**RE: Design Review Panel (DRP) – Tuesday 11 November: Meeting 2.3
Green Square Town Centre HDA Scheme - SSD-83899206**

Thank you for the opportunity to review the pre-SSDA proposal for Stage 3 of the Green Square HDA Scheme (Sites 7, 17 and 18). The advice provided in this letter relates to the second formal design review session held on Tuesday 11 November, primarily focused on the detailed design of Stage 3 and also addresses the Panel's comments raised in the first DRP and interim sessions.

BASE RETAIL

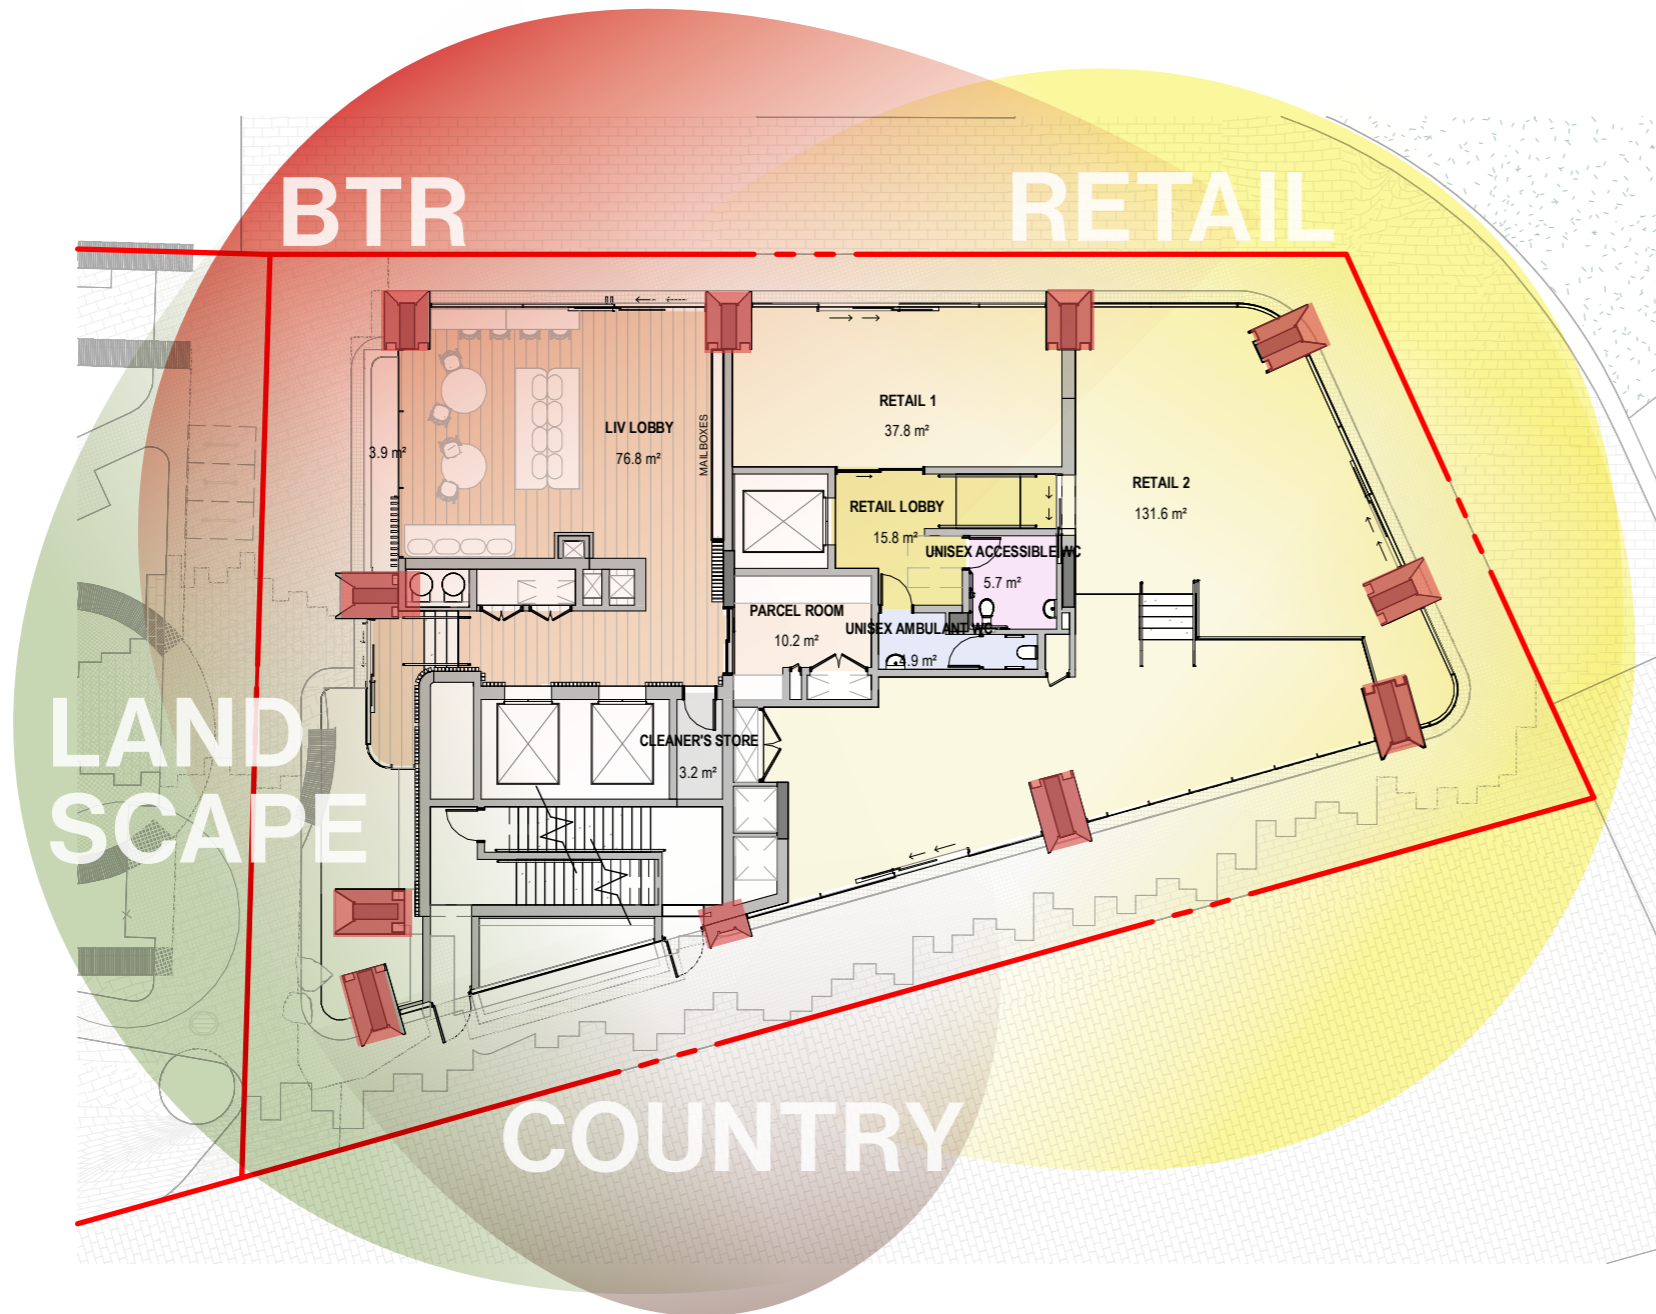
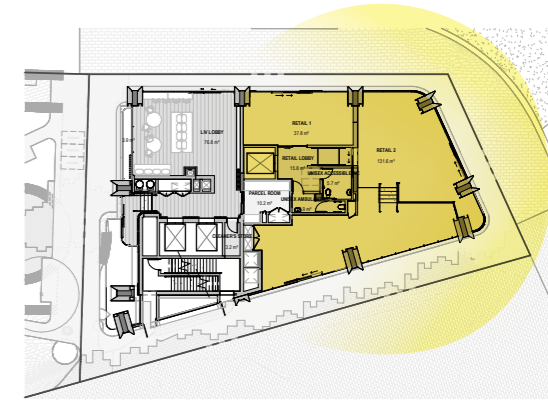
18. The design response at the base of Site 18, particularly with regard to the height of the awnings, the expressive tapering columns, egress stair discharge point, and landscape planter beds should be revised to prioritise the plaza edge and public activation, also considering wind and rain protection.

TOWER COMMUNAL

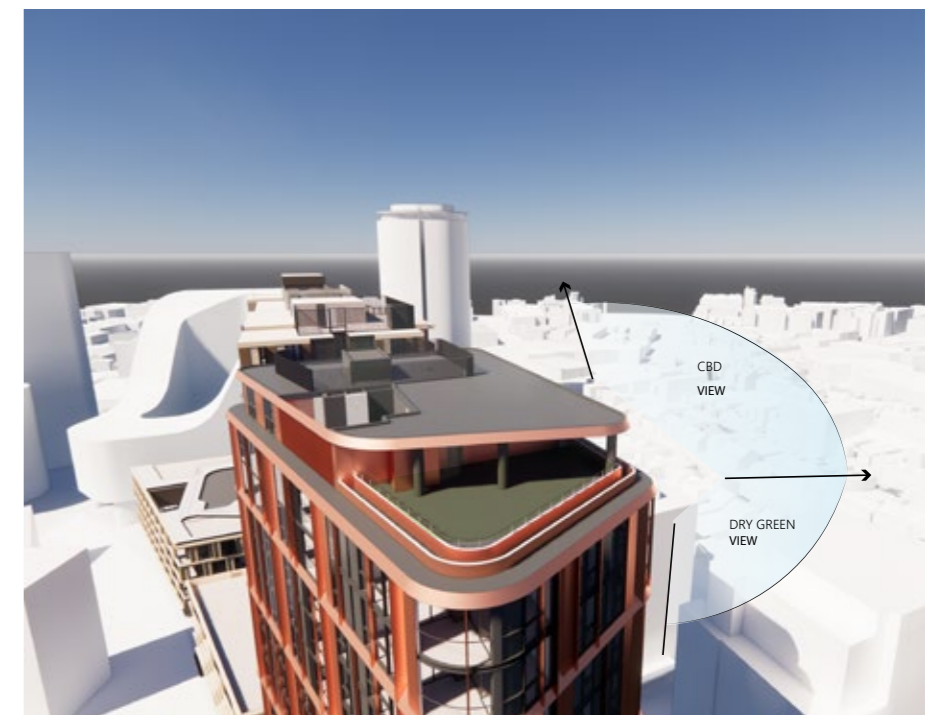
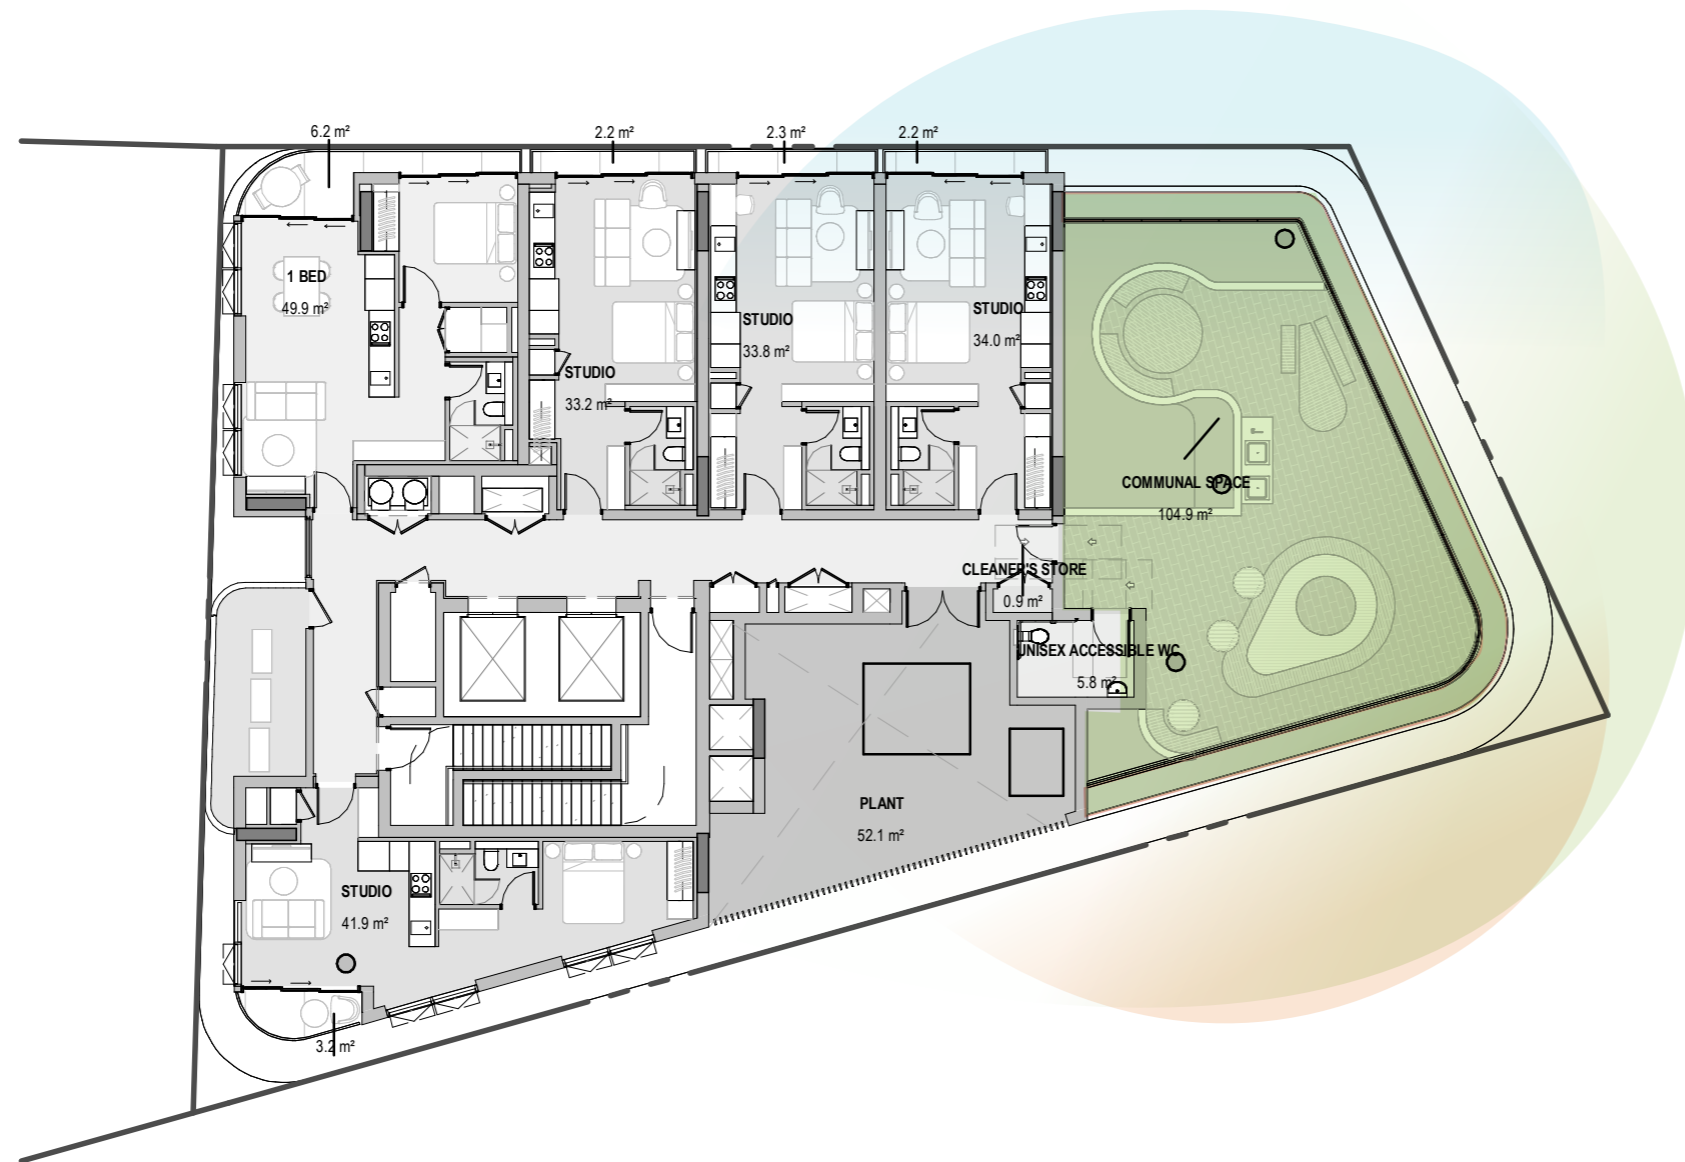
20. There may be a need for increased self-shading on towers and the depth of facade elements should be increased significantly.
21. Further interrogation of the design of roof forms should be provided for each building so these elements are properly composed and well-integrated. The Panel recommends the provision of landscape and amenity features such as BBQs, toilets and a kitchen to be provided on the rooftop communal space for residents. The amenity of the roof terrace of Site 7 is supported and the roof terrace of Site 18 should be further developed to align with Site 7's level of amenity.

Site 18 - ADG NATURAL VENTILATION

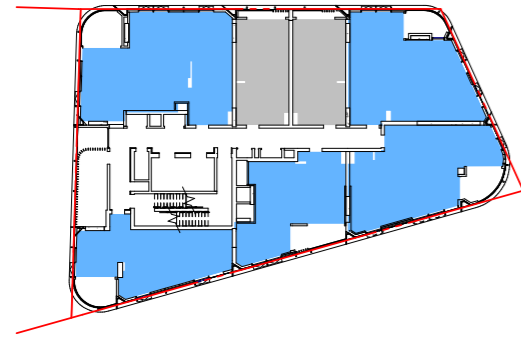
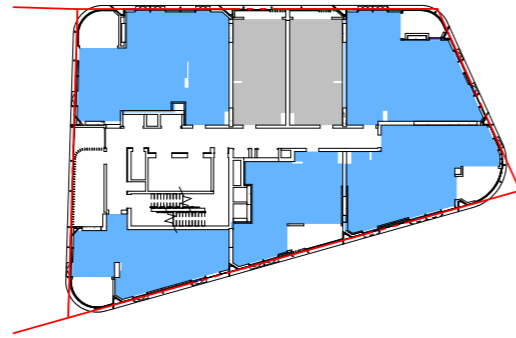
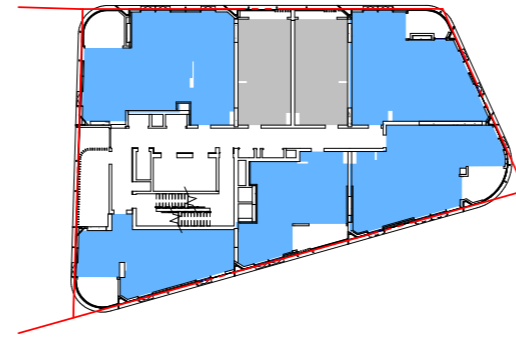
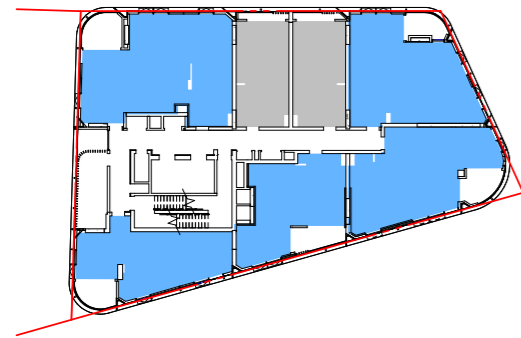
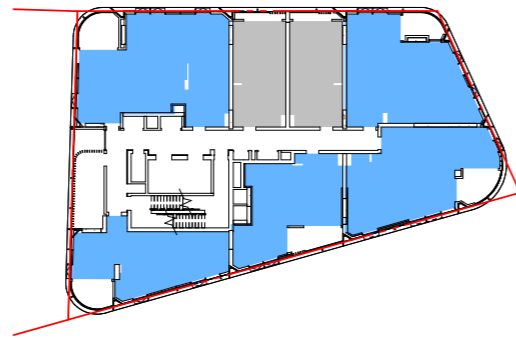
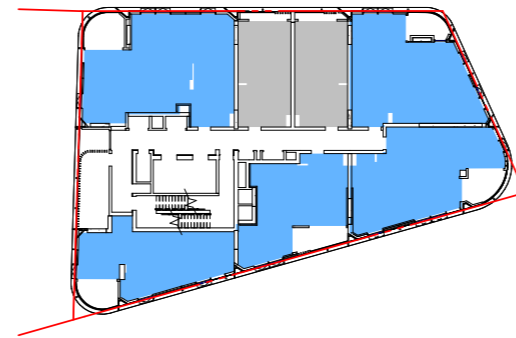
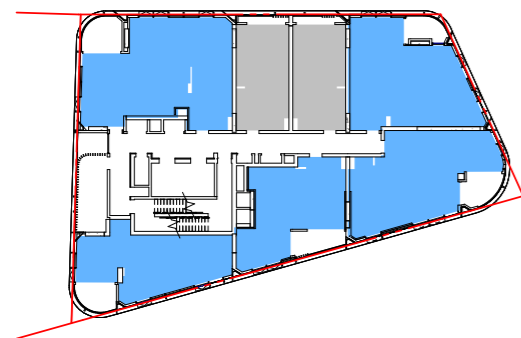
25. **ADG Compliance:** Compliance with key ADG targets should be interrogated and confirmed in the submission, in particular the approach to quantifying cross ventilation appears to include a number of single-aspect apartments relying on notches to achieve natural cross-ventilation. By further developing compliance with natural cross ventilation and solar access, opportunities may arise to meaningfully improve the expression and hierarchy of facades.
26. **Landscaping and Public Domain:** The Panel recommends that further clarity be provided on the ongoing discussions with Council relating to the design and landscaping of public streets throughout the Precinct.
27. **Affordable Housing:** Further clarity should be provided on how affordable housing will be distributed and managed across the Precinct.
